ONLINE COMMENT ON PLANNING APPLICATION 21/10013

Location 140 SALISBURY ROAD, TOTTON SO40 3LQ

Objection received from Mrs Lisa Riddett
138a Salisbury Road
Totton
Southampton
SO40 3LQ

Drwg. No.  
4826/02

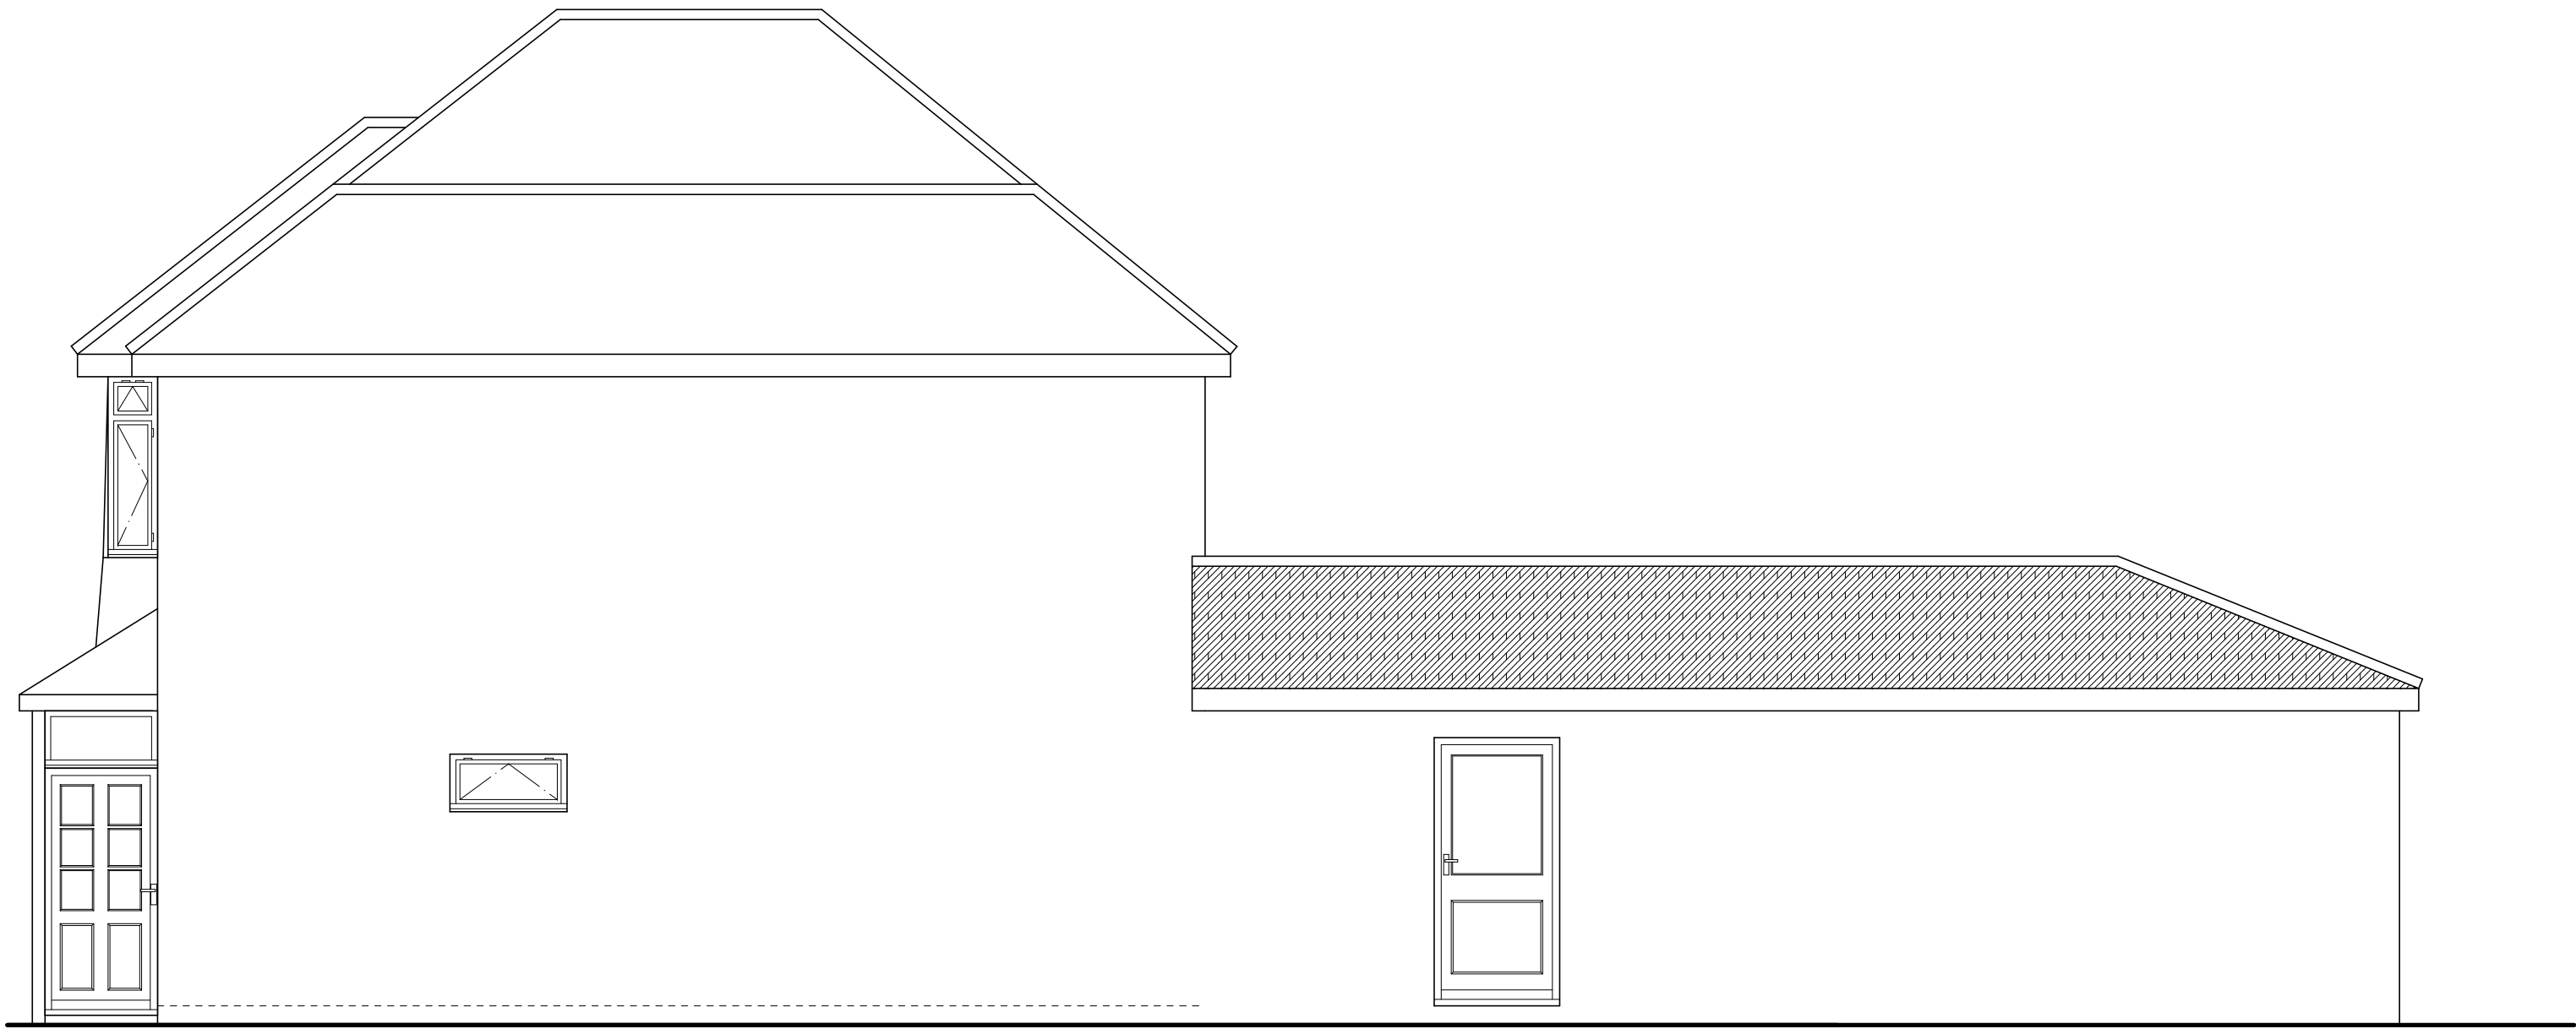
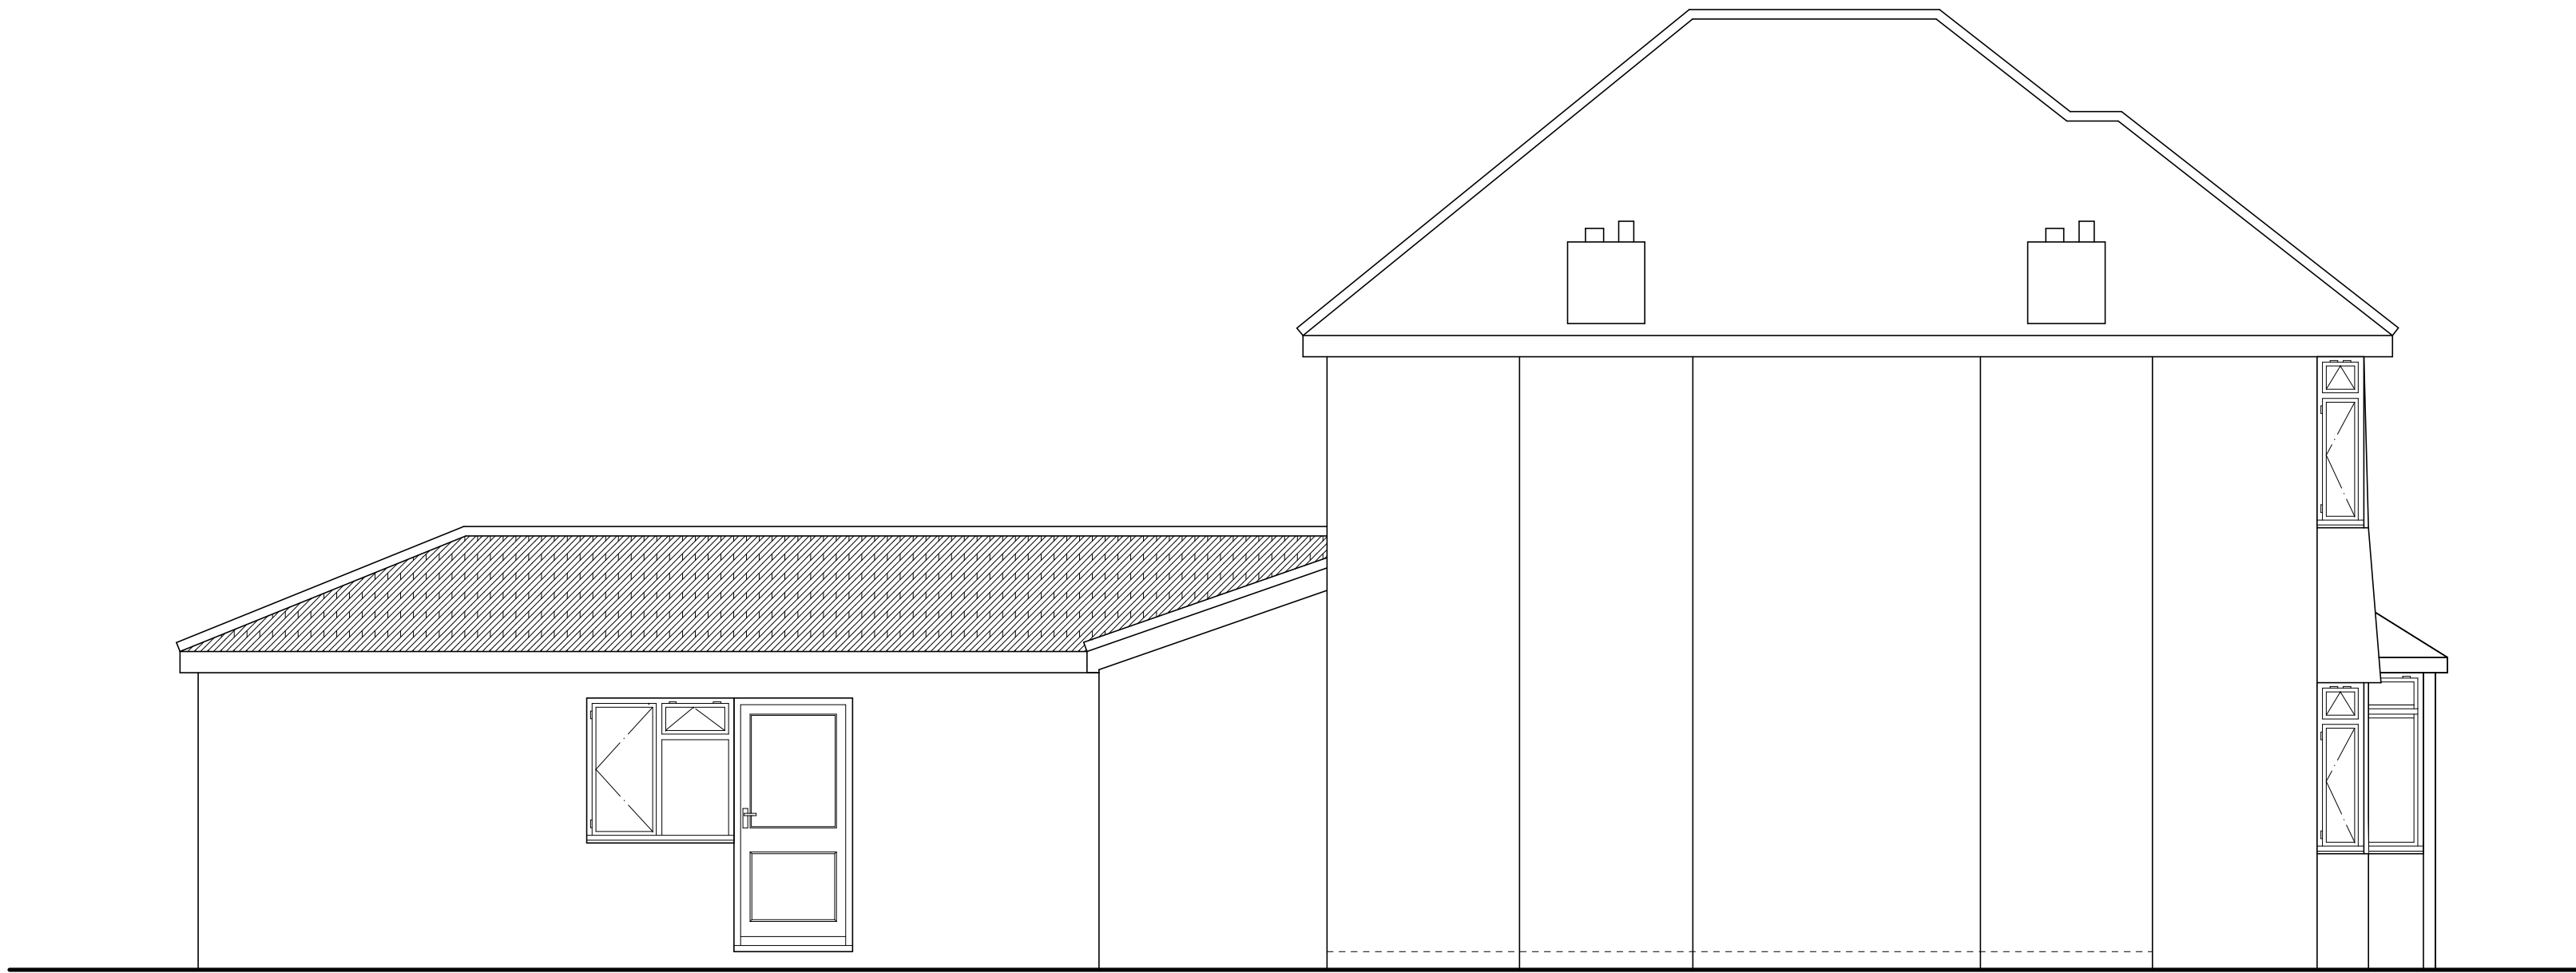
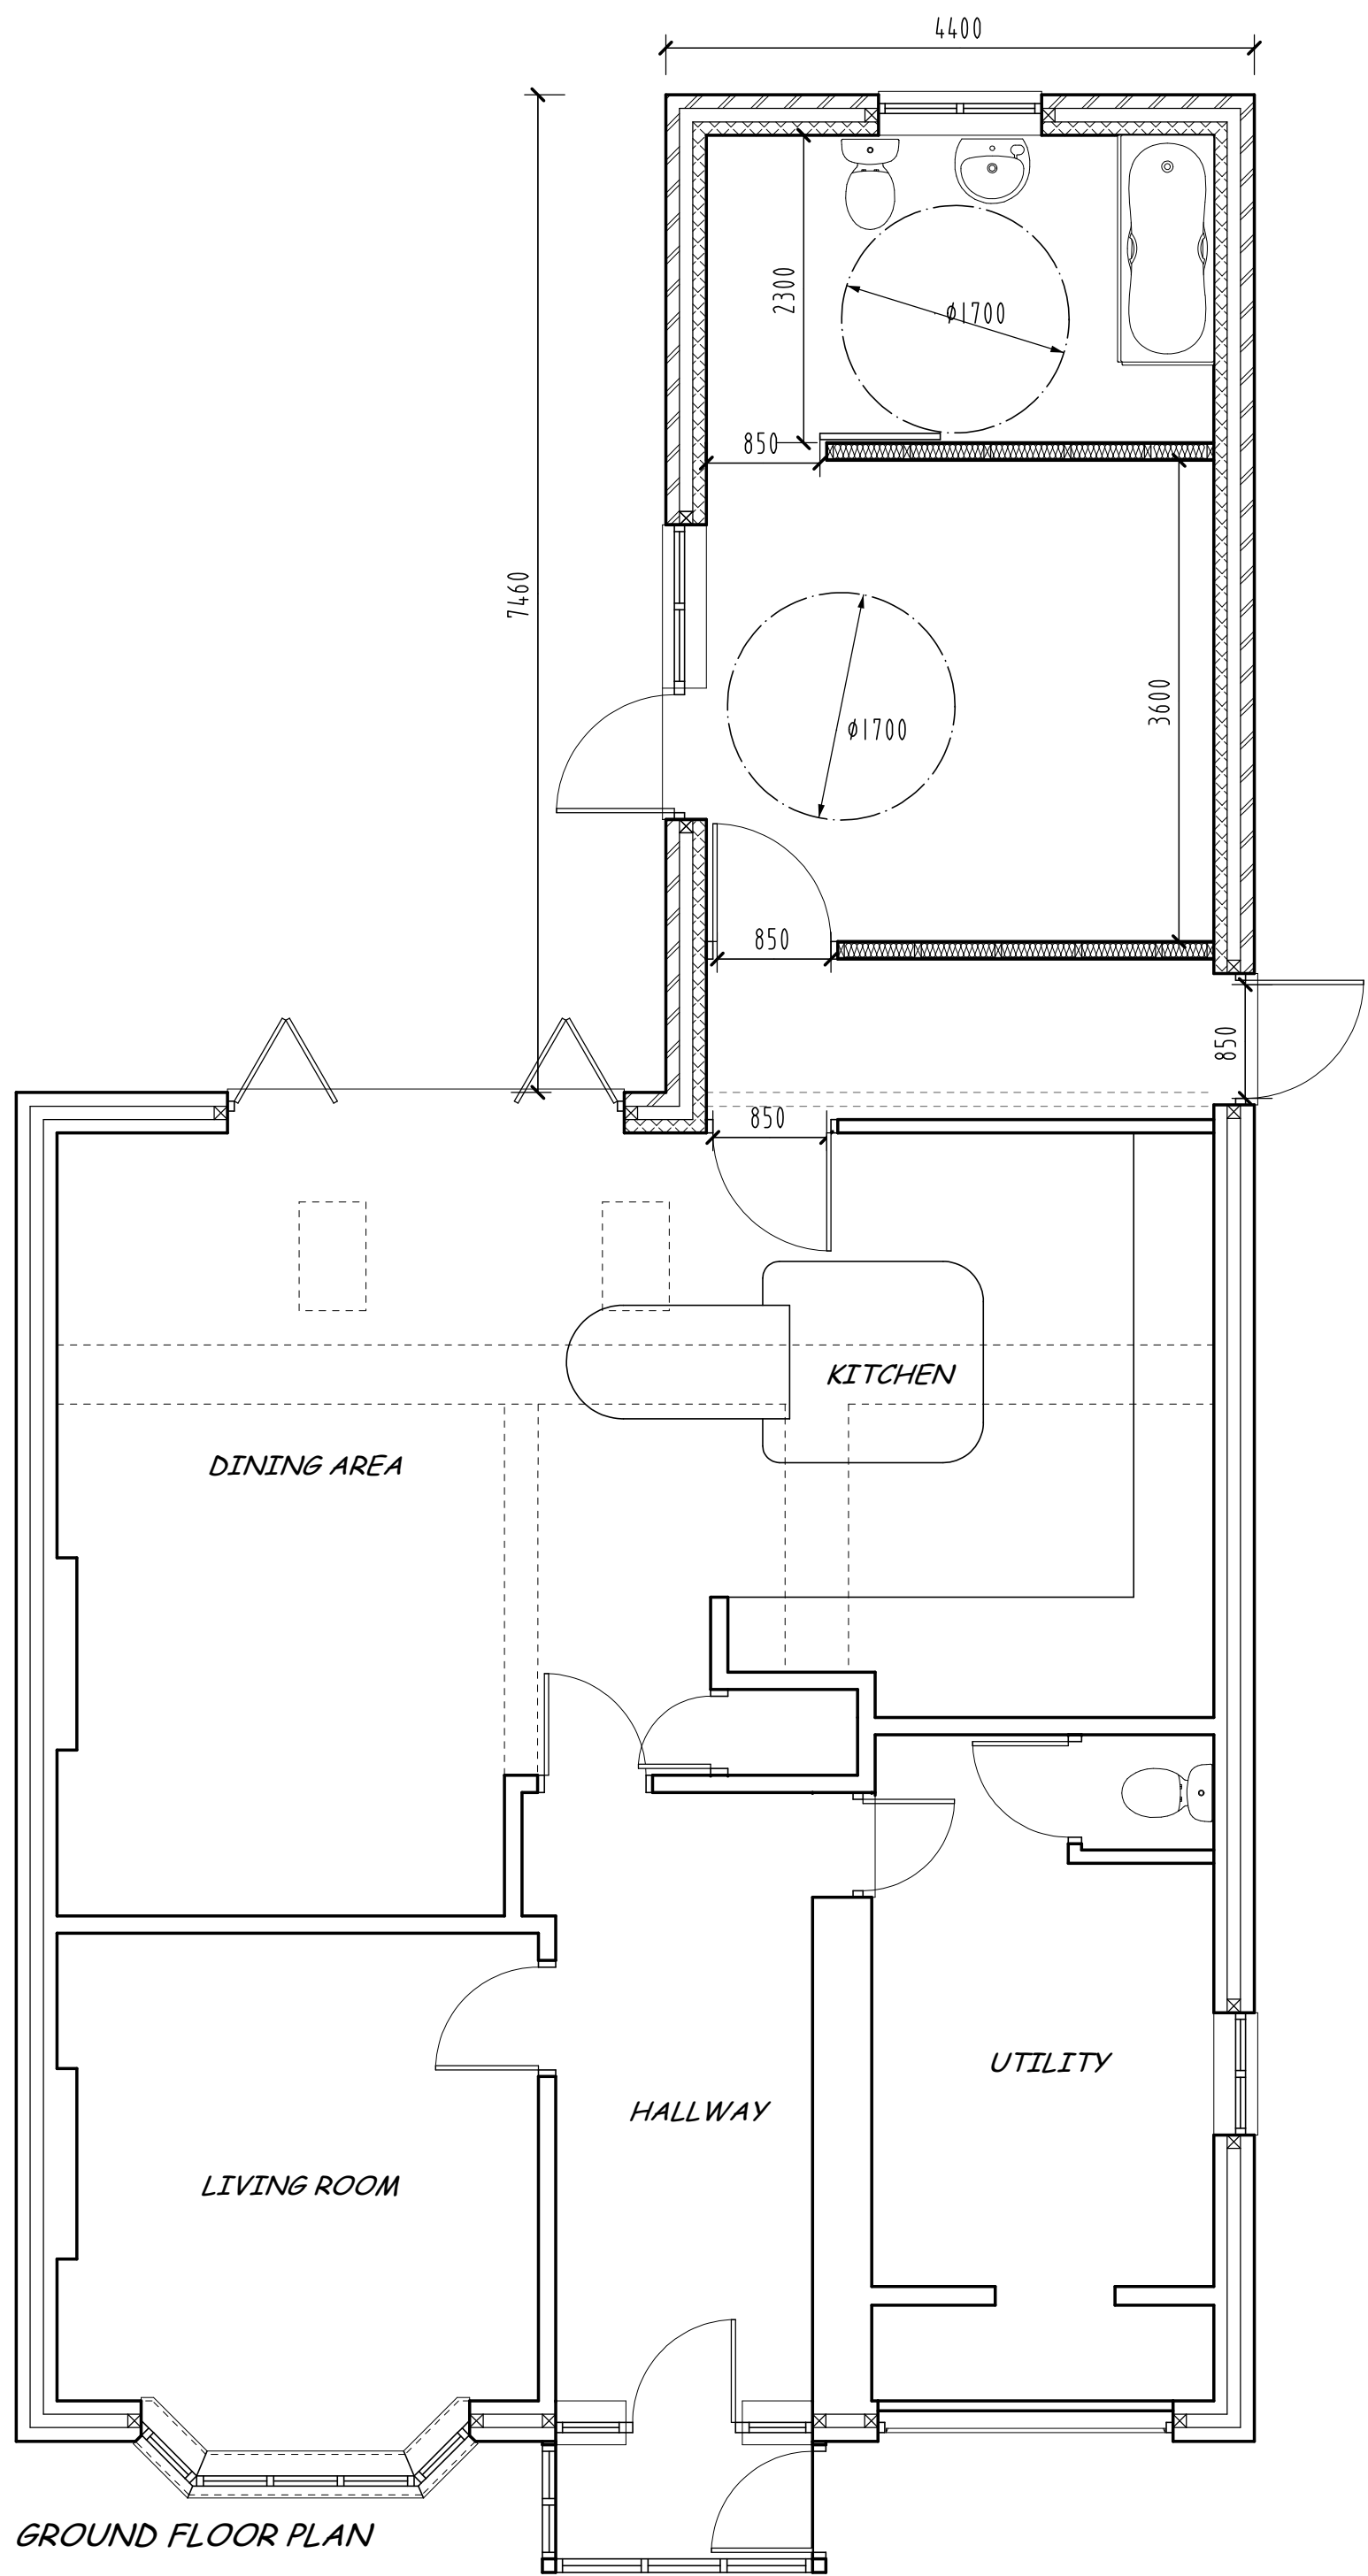
Comment: Strongly oppose to this ,being direct neighbours our garden is only Aprox 30ft long and very small in comparison to the plot it is being built on this will effect us hugely!! Not only is the extension very long compared to our plot it is also quite high , but n effect higher than our 6ft boundary fence
This will effect a huge amount of sunlight into our garden we don't get much as it is already .our son has a medical condition and need the sunlight he spends a lot of time in the garden in the summer as we all do and it will effect out quality time outside massively this will also create more damp to our house being in the shade more so .
We are set further back from this property and already feel boxed in as a higher fence has been erected to the front by the same residents
